Rezoning Petition Review

Rezoning Petition #: 08-125

Location of Property: Approximately 70.91 acres located on the southwest quadrant of the Mt. Holly Rd. / I-485 Interchange

**STORM WATER MANAGEMENT**

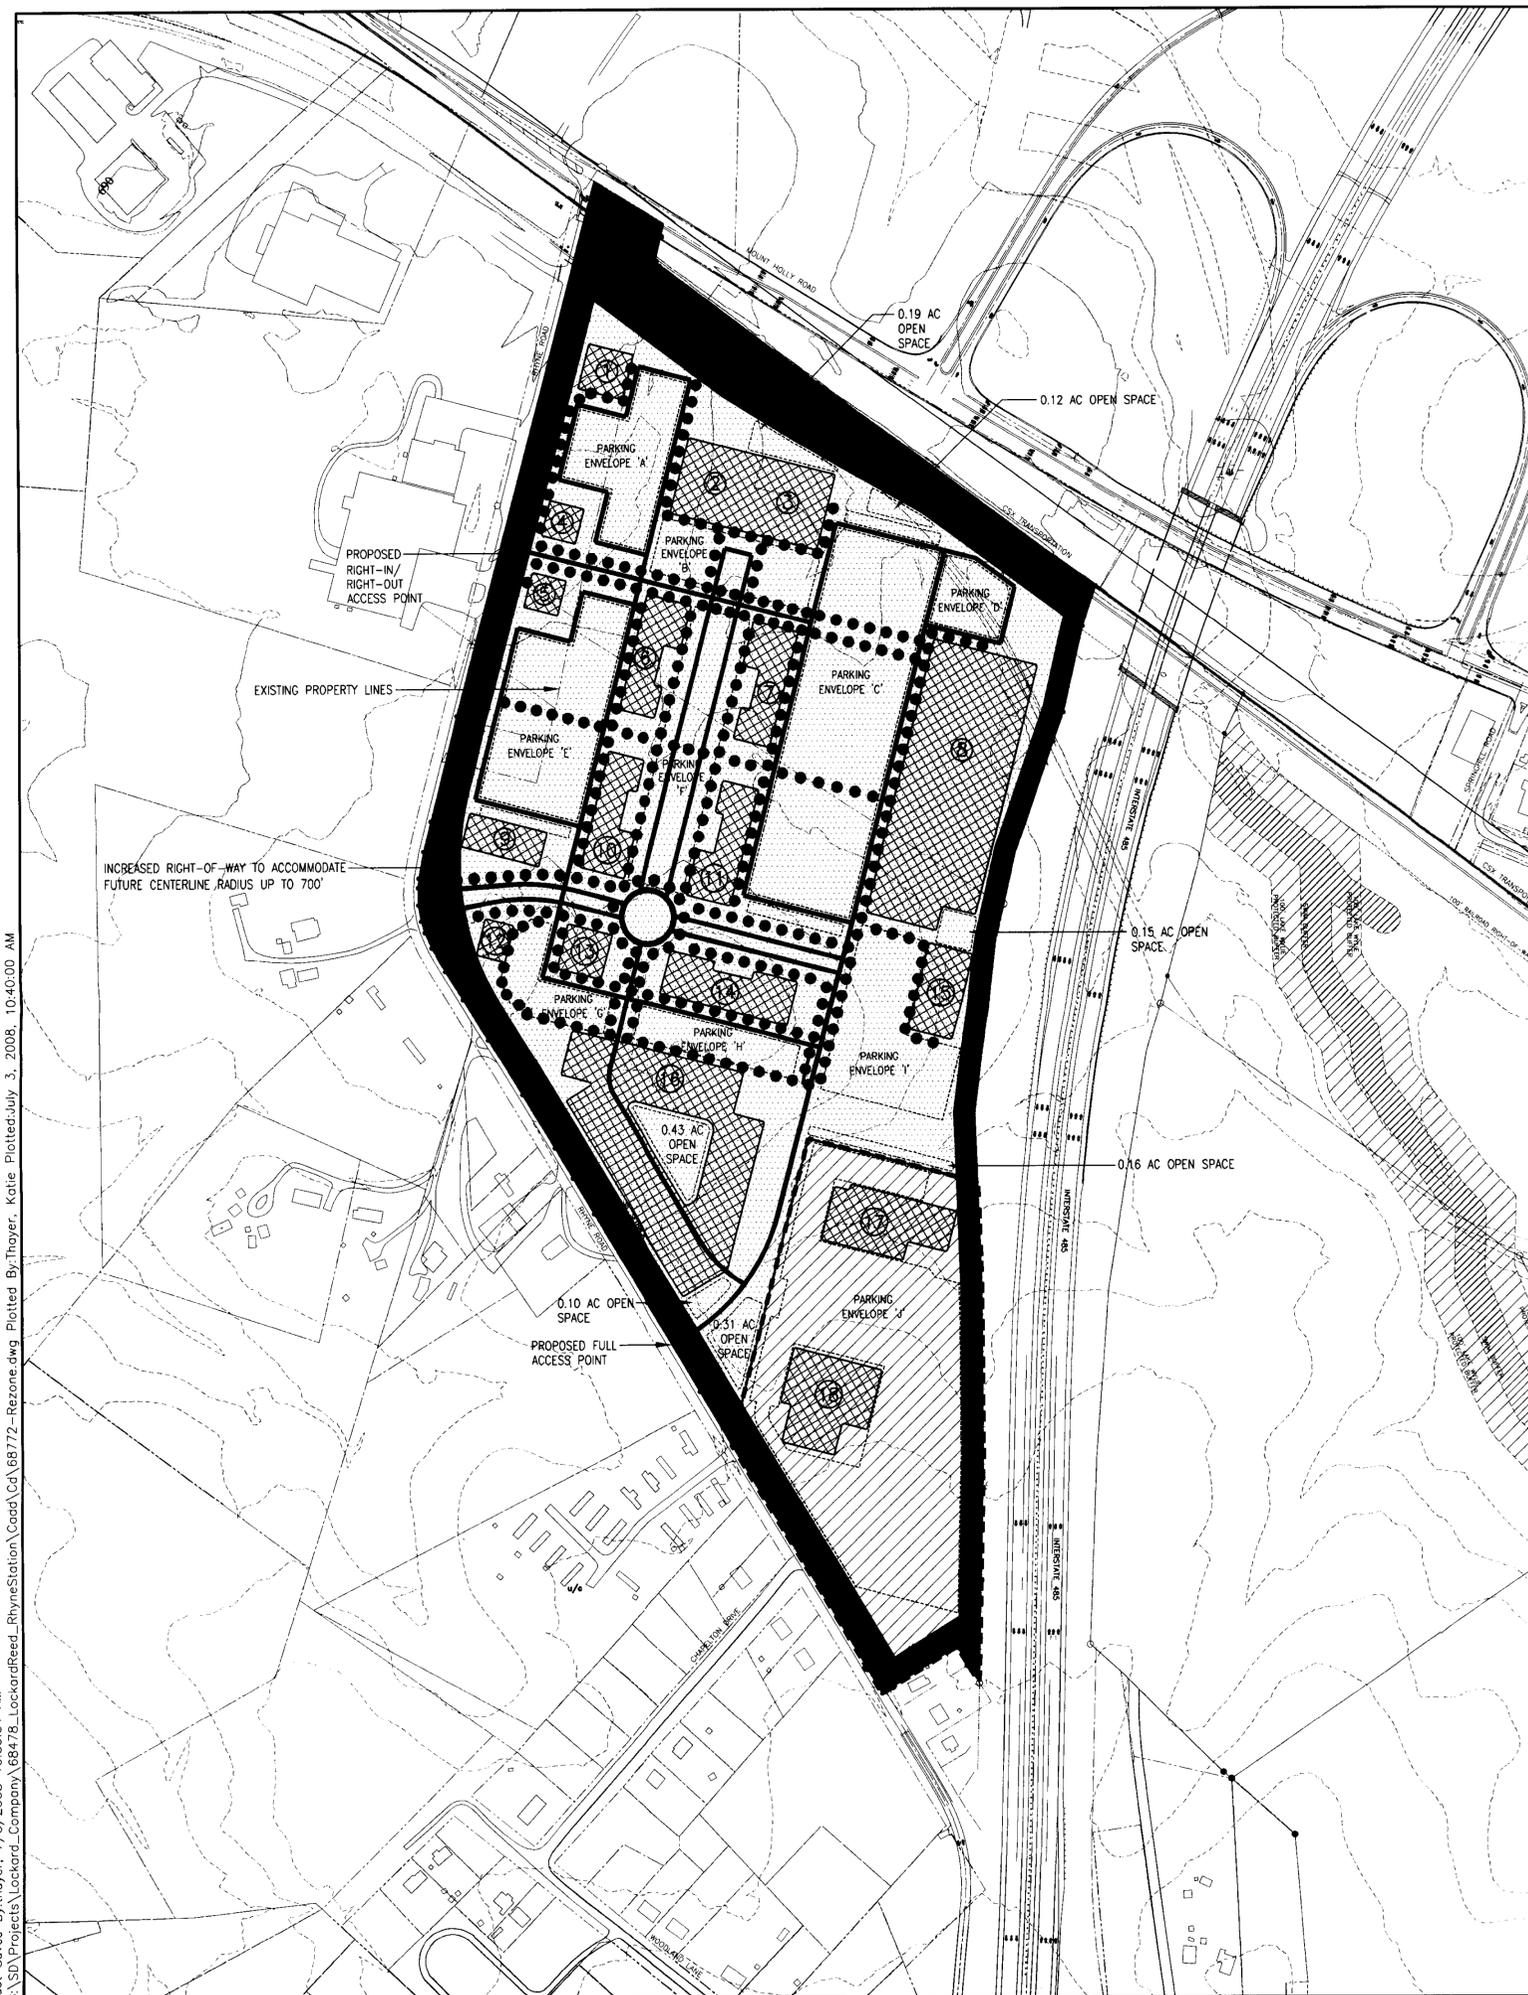
**Recommendations
Concerning Storm Water:** **Please remove Storm Water Management notes and replace with the following note**

The petitioner shall comply with the Charlotte City Council approved and adopted Post Construction Controls Ordinance.
